From: Neil Champion [REDACTED]
Sent: 10 November 2020 10:13
To: Nicola Moore
Subject: Re: Request for further information AW/312/20/PDH
Attachments: Block Plan 2020-11-10.pdf

With reference to our application ref: AW/312/20/PDH for 33 Gossamer Lane, PO21 4BX, please find attached the requested block and location plan.

BLOCK PLAN
SCALE 1:500 @ A1

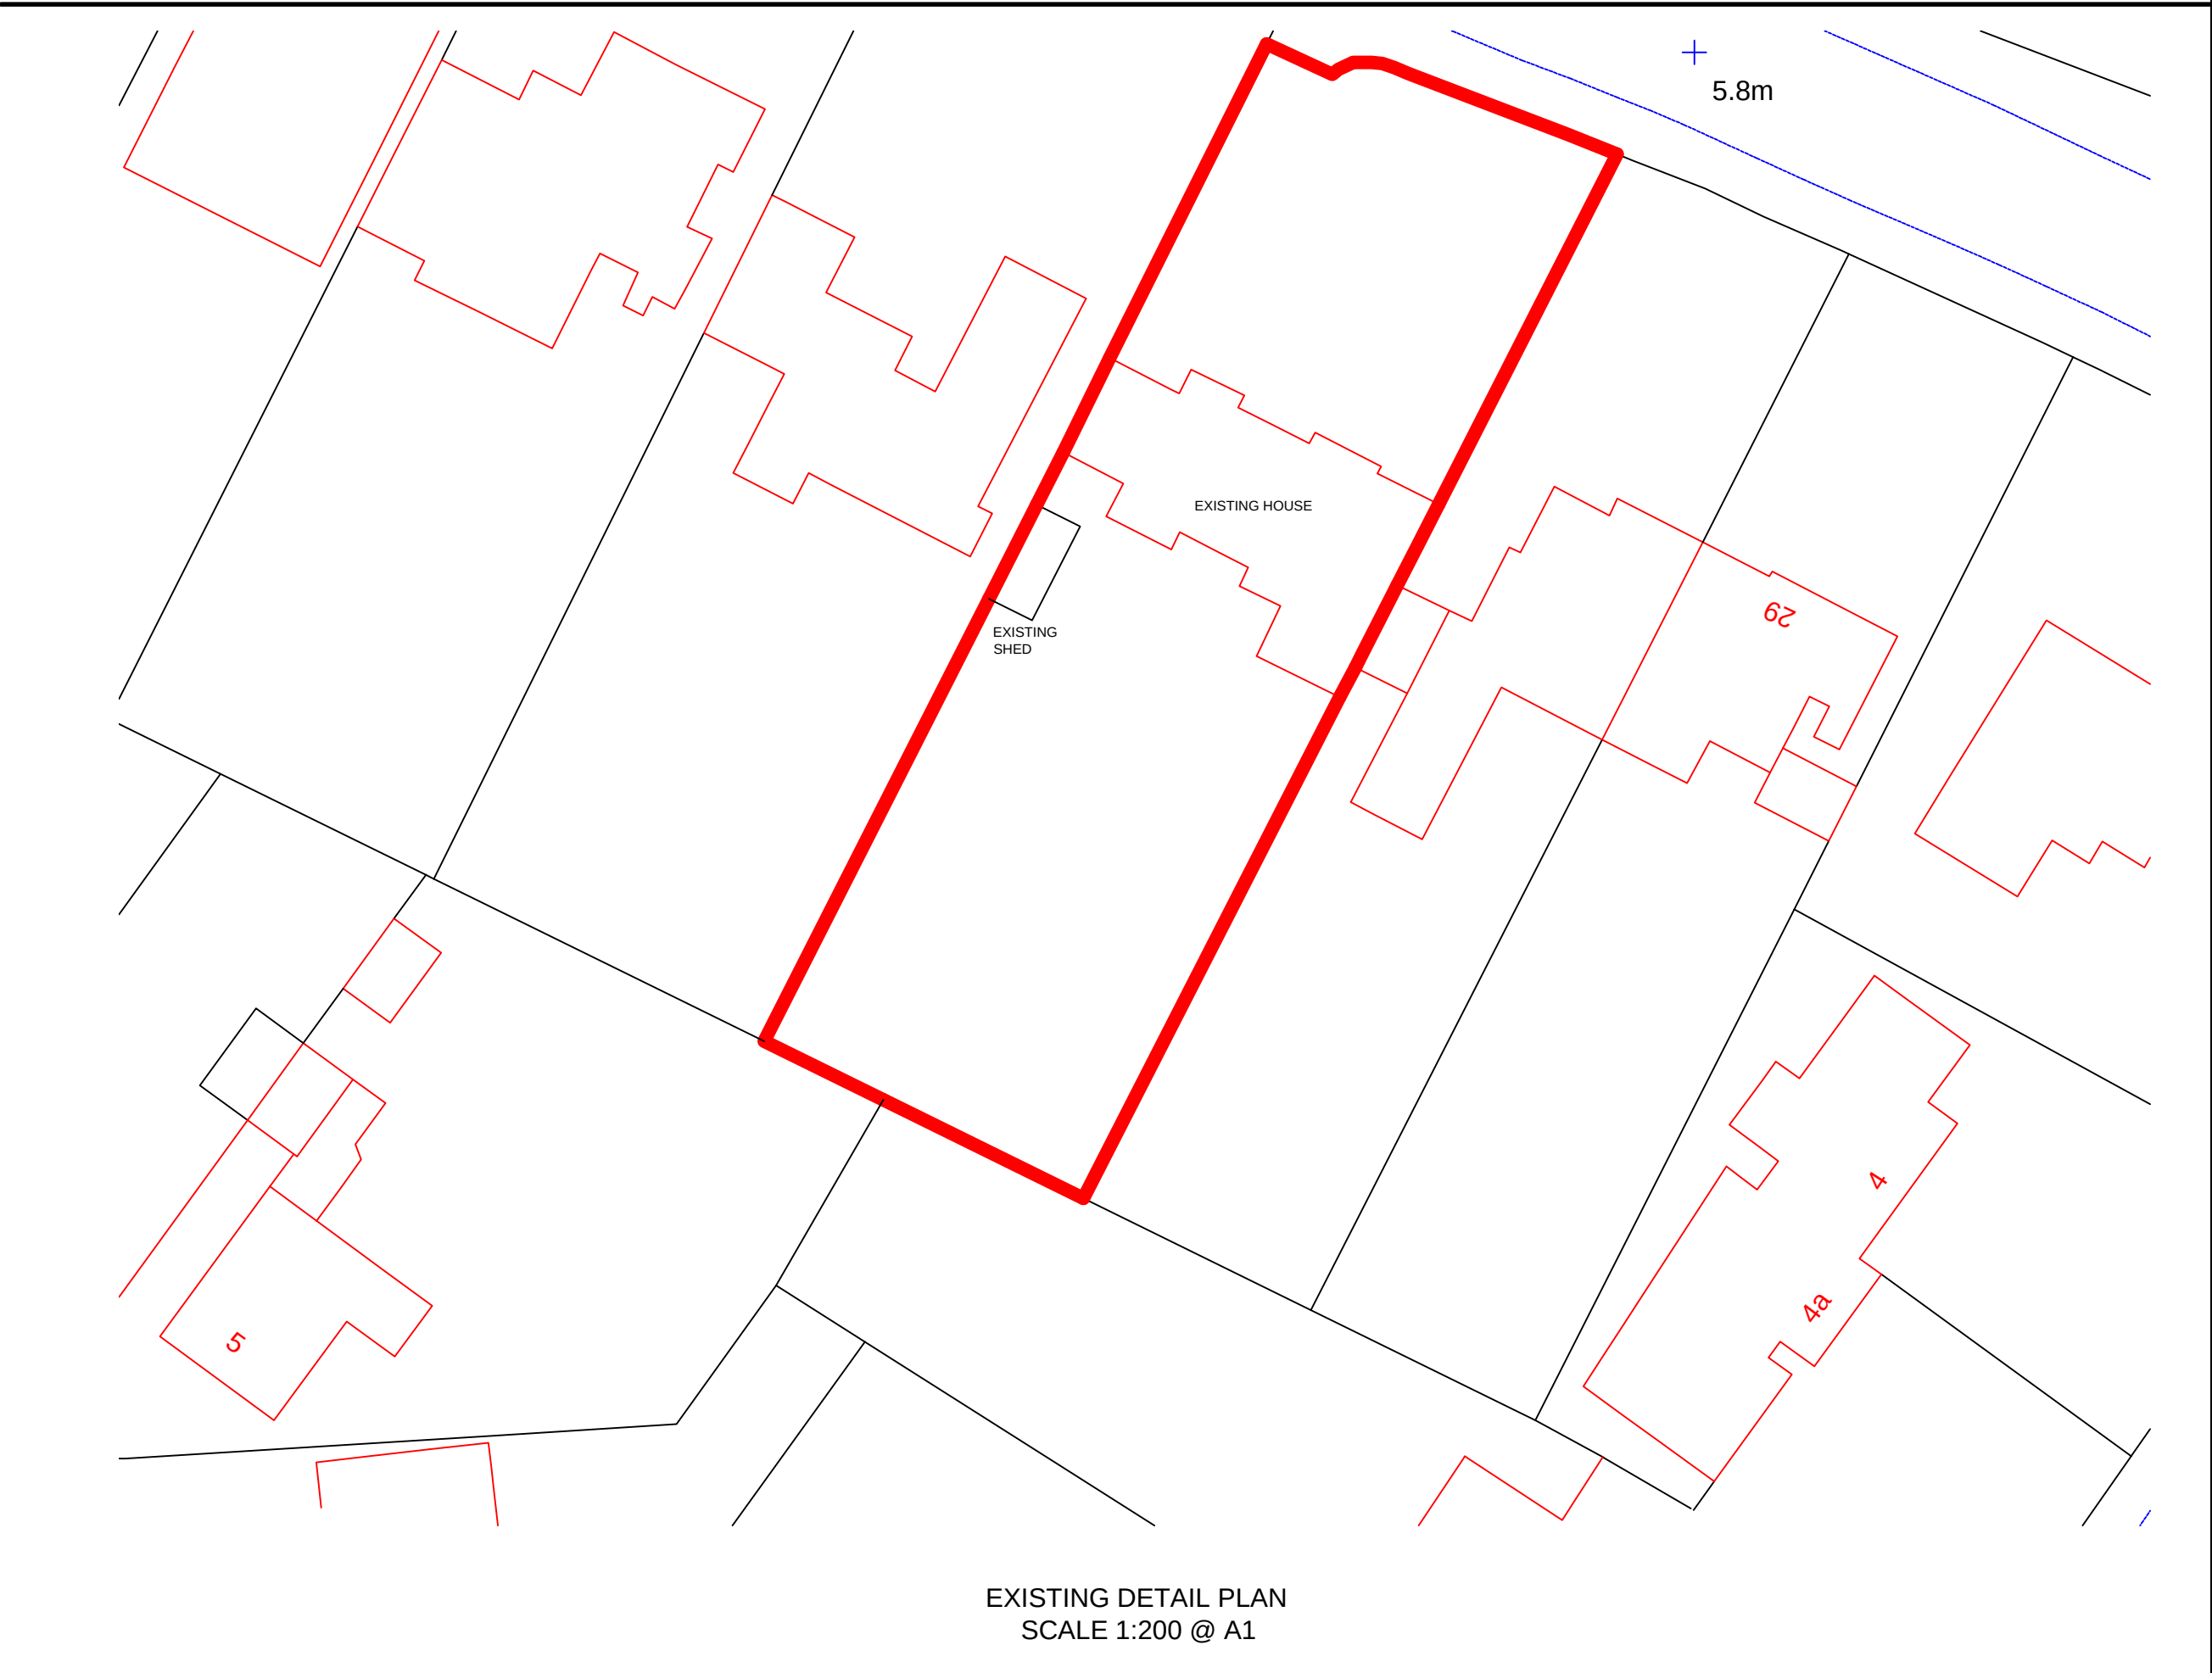
Thank you for the Location and Block Plan received today. The Block Plan should show the proposed development in relation to the site boundaries (this can be hatched, highlighted or colour) and the dimensions to the boundaries.

Please amend accordingly and resubmit.

Updated drawing attached, if you could let me know this captures all required?
